Our Case Number: ABP-314724-22

Re: Railway (Metrolink - Estuary to Charlemont via Dublin Airport) Order [2022]
Metrolink. Estuary through Swords, Dublin Airport, Ballymun, Glasnevin and City Centre to Charlemont, Co. Dublin

Our Ref: 2193 General Submission

Re: Railway (Metrolink–Estuary to Charlemont via Dublin Airport) Order 2022

Charlemont LUAS stairs & lift connection 2024

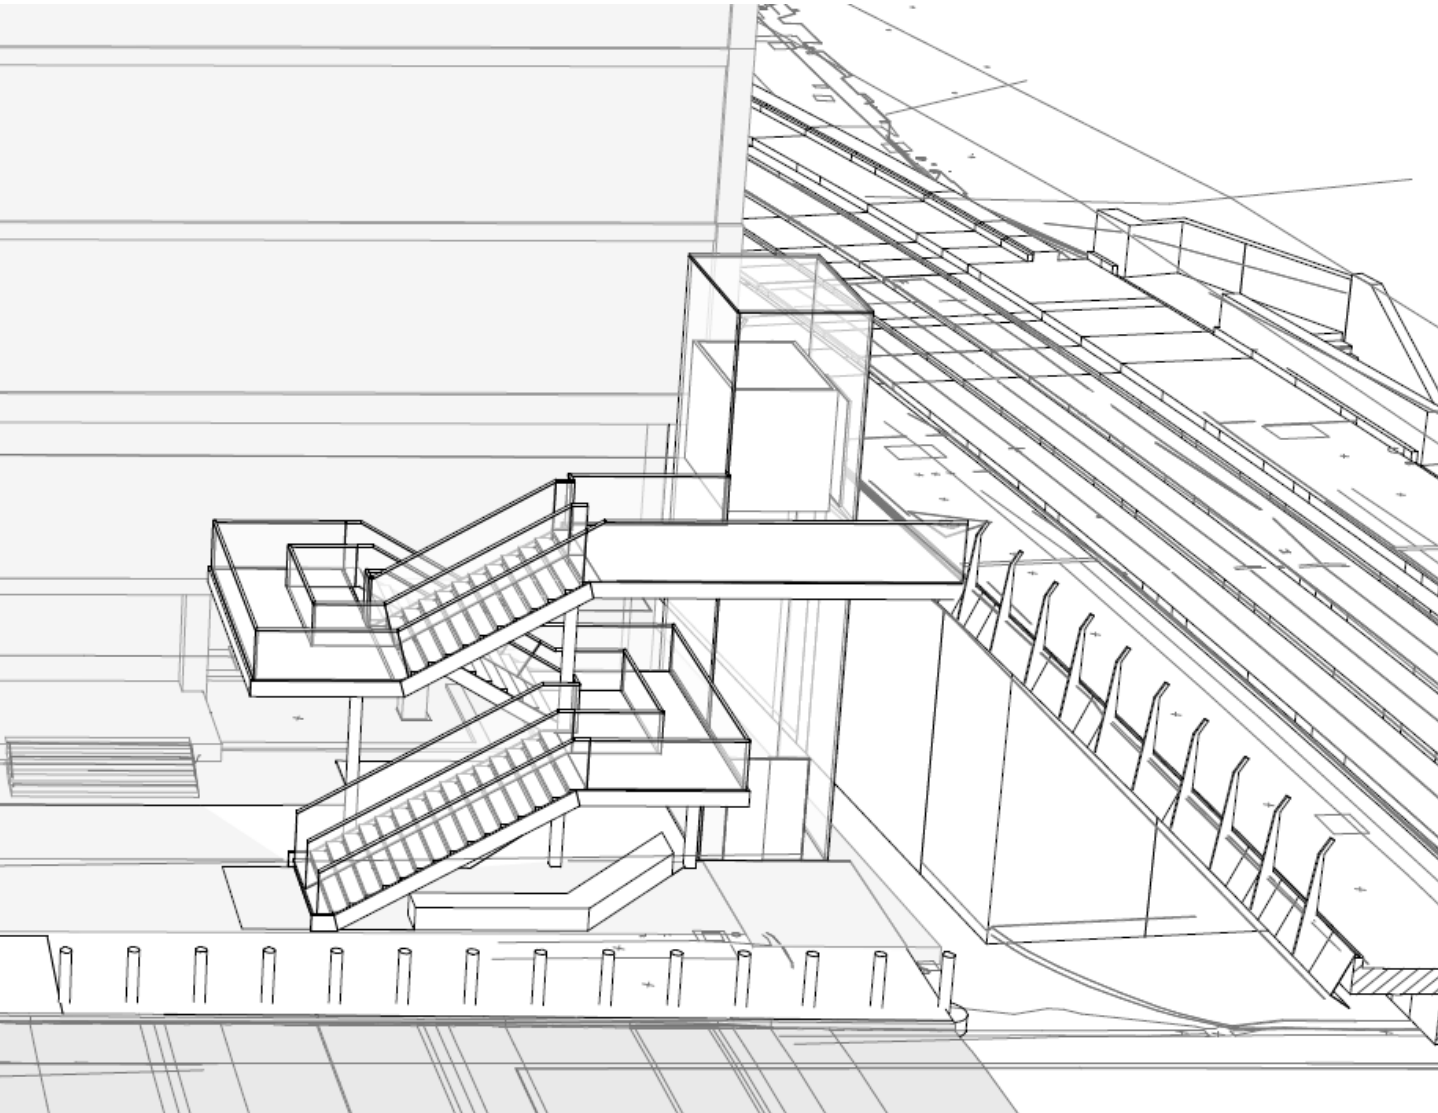
A document entitled *Charlemont LUAS stairs & lift connection* was submitted to the Oral Hearing. According to the Applicant, the interchange between Luas and Metro at this point is a major aspect of the project. This arrangement is illustrated in the extract below.

This flight of stairs is the main interchange between these two modes, which will have to accommodate all passengers including those with baggage who are either coming from, or going to the Airport. In the document submitted to the Oral Hearing *Passenger at Charlemont Station, St. Stephens Green East, Tara Street Stations*, it is indicated that in 2035 there would be 29,537 passengers interchanging in 12 hour period. Of this figure, c8,000 would be accessing Luas. The

figures are not provided for the peak period which is an average of 666 passengers per hour. One can assume that the peak period would be multiples of this figure. Yet amazingly, the two flights of are only 1.2m in each direction. While there is a provision of a lift there is no escalator up the Luas Station. This is less than a minimum footpath width on a standard road, let alone that which would be required for high volumes of pedestrians interchanging between Luas and Metro. This will undoubtedly give rise to a danger to pedestrians and passengers. Again, the nature by which this information was submitted at the Hearing, it has not been possible to pose relevant questions to the Applicant.
